30<sup>th</sup> April 2021.  
JAC/JH/14192.

**RE: MINOR MATERIAL AMENDMENT TO PLANNING PERMISSION REF: DA/20/00015/VCON, SUBSEQUENTLY AMENDED BY VARIATION OF CONDITION APPLICATION REF: DA/20/00639/VCON TO ALLOW ERECTION OF DWELLING TO CONFORM TO AMENDED DRAWINGS.**

Drawing: **DHA/14192/SK04A** Rev: Scale: **1:100** Date: **MAY 2020**

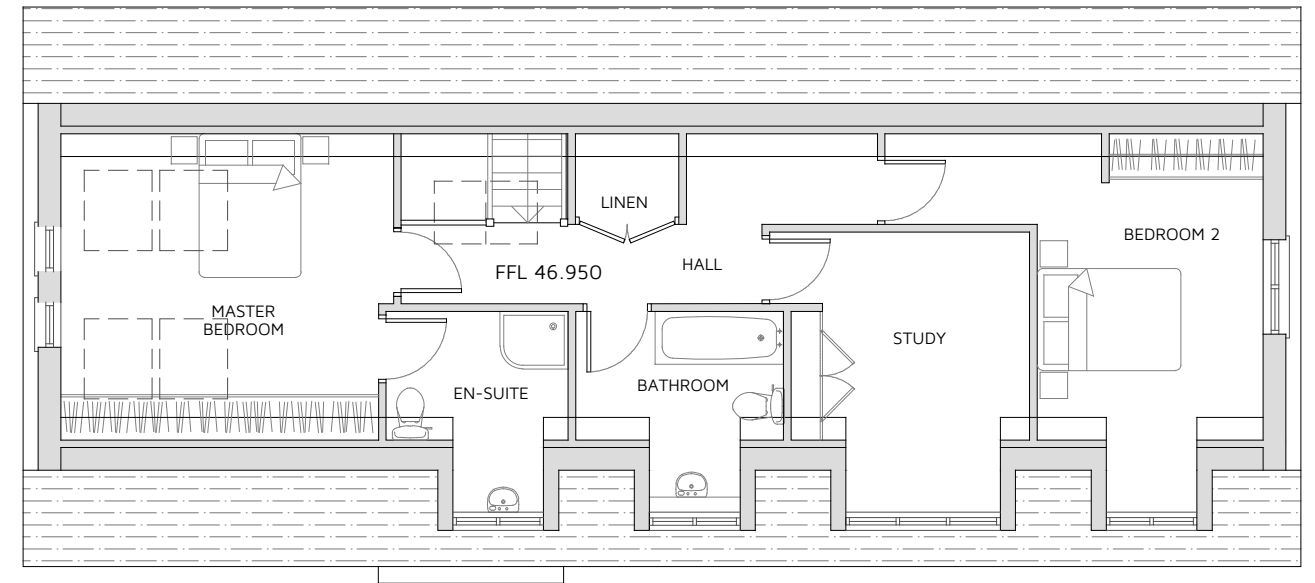
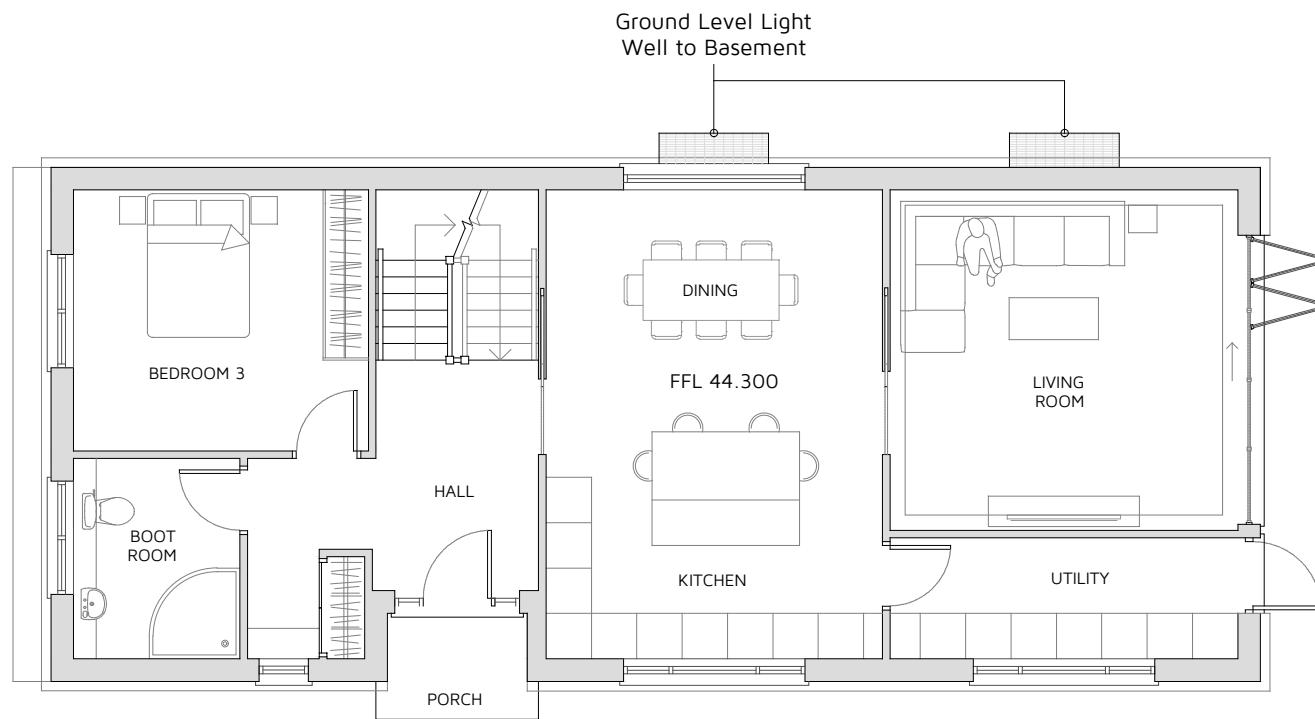
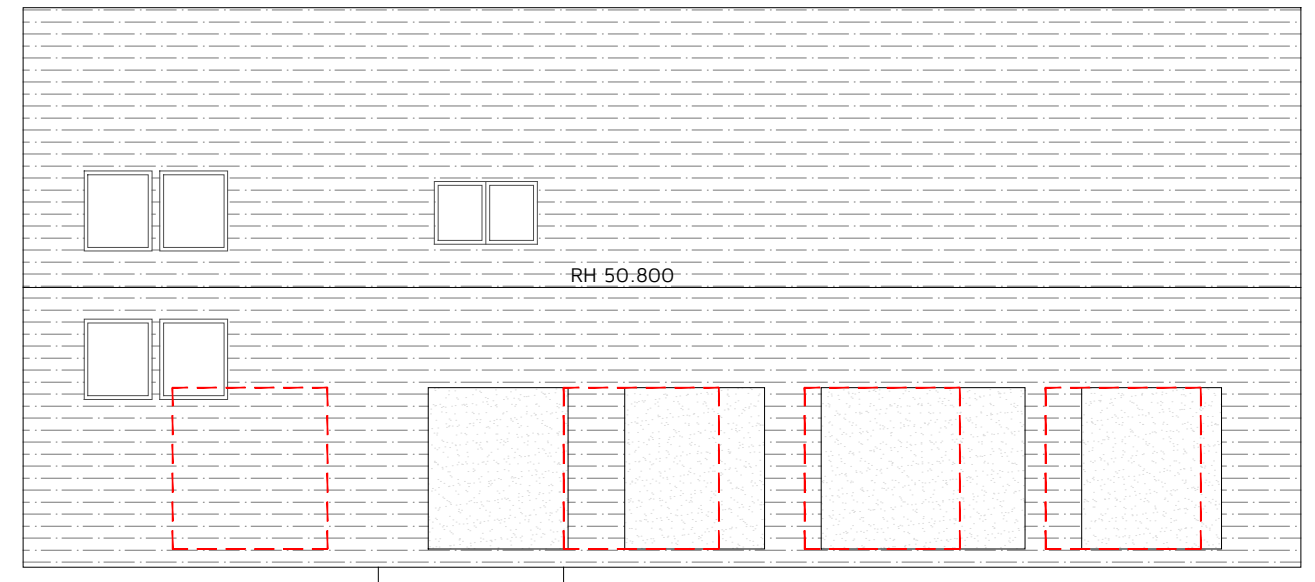
The amended scheme proposes the same amount (4no.) of dormer windows along the same southern roof pitch, albeit with slightly amended dimensions and positions. The westernmost dormer window will now provide light to the en-suite of the master bedroom, with the remaining three dormer windows still providing light to the bathroom, study and bedroom 2.

The amended drawings retain the two rooflights which serve the hallway in order to provide appropriate daylight/sunlight to the core circulation areas. The amended drawings propose two rooflights on both the southern and northern pitch of the roof, increasing the amount of rooflights to five overall.
